Heckington Fen Solar Park

EN010123

Cover Letter

Change Notification (our document reference – PreExA.CL.CN.v1)

PLAN VIEW  
 (SCALE 1:150)

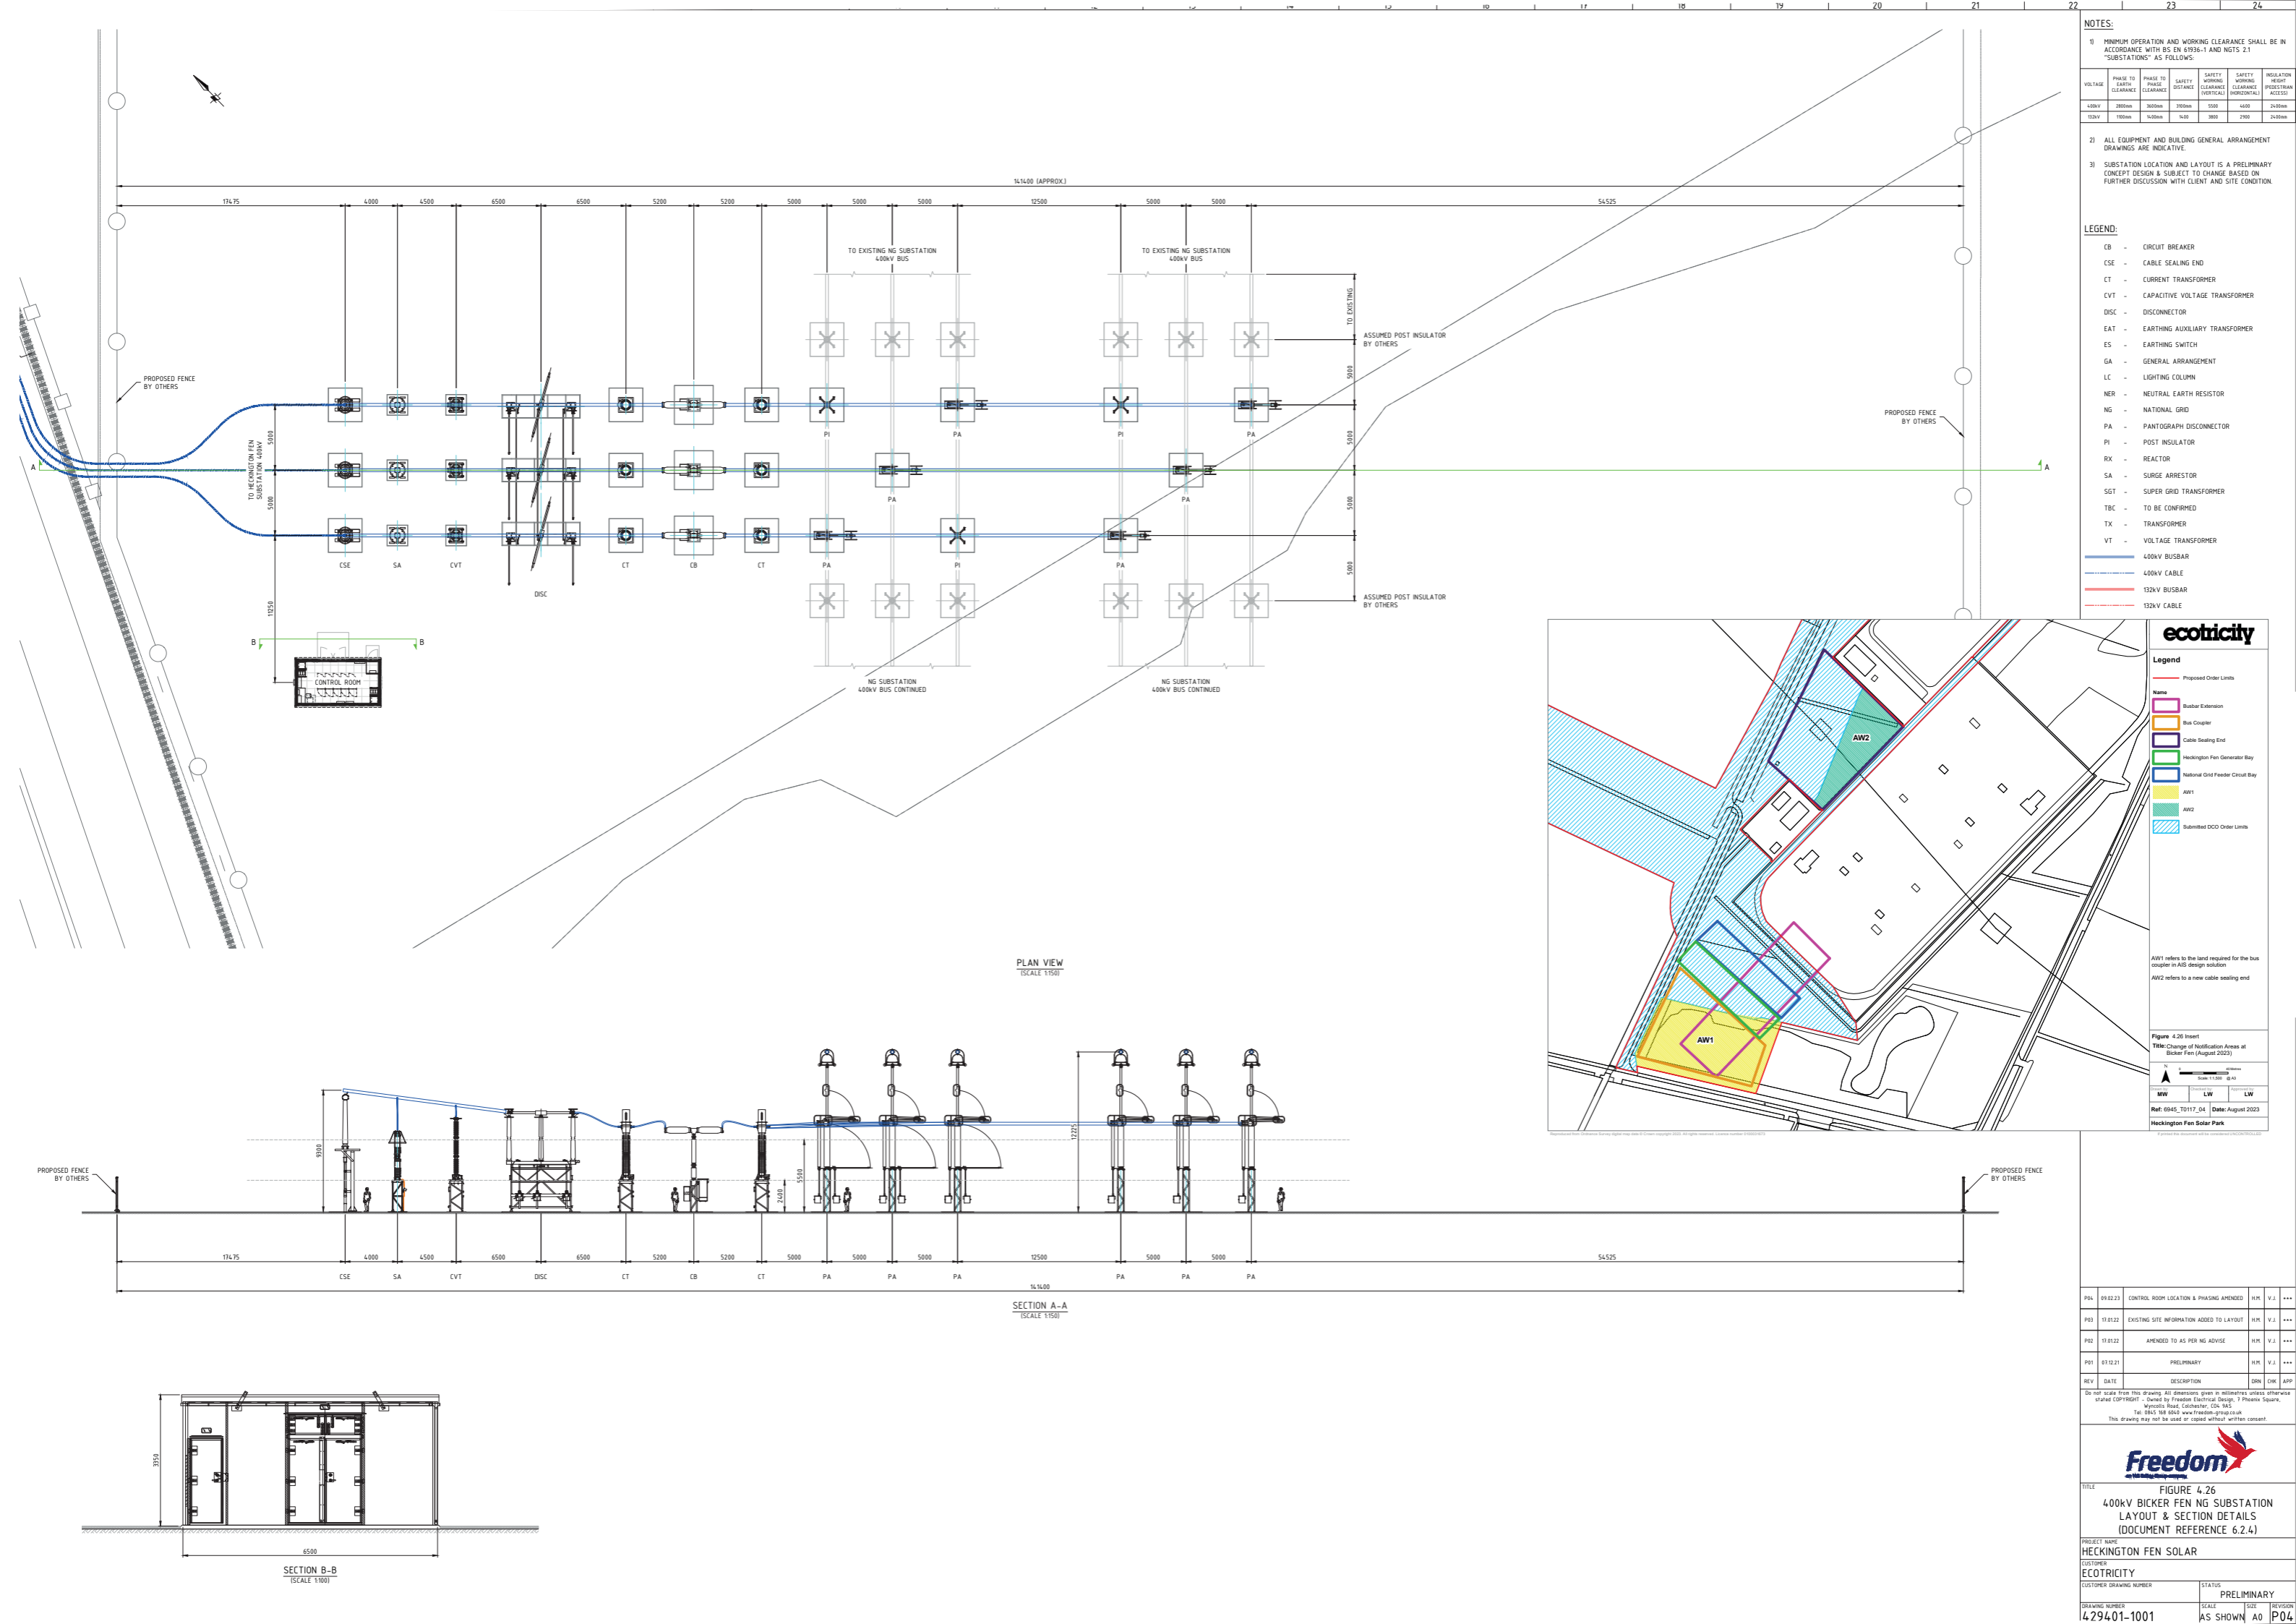
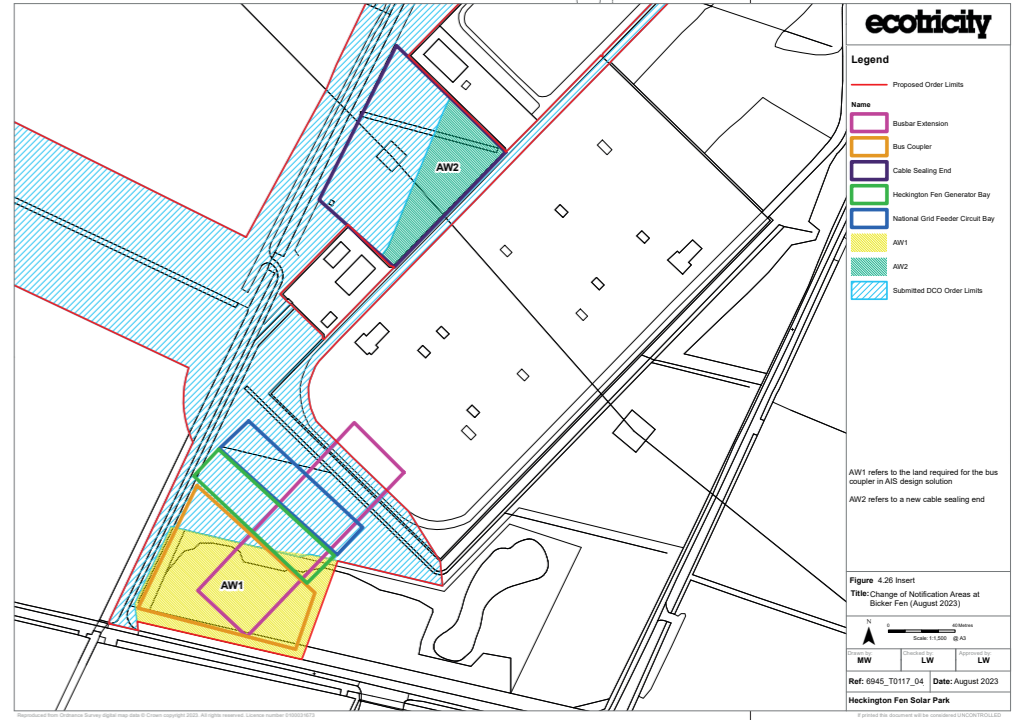
In addition, NGET require optionality over the type of insulation required for the switchgear and so the relevant parts of Work No.6A and 6B in the revised DCO will be updated to include the option for Air Insulated Switchgear (AIS) or Gas Insulated Switchgear (GIS).
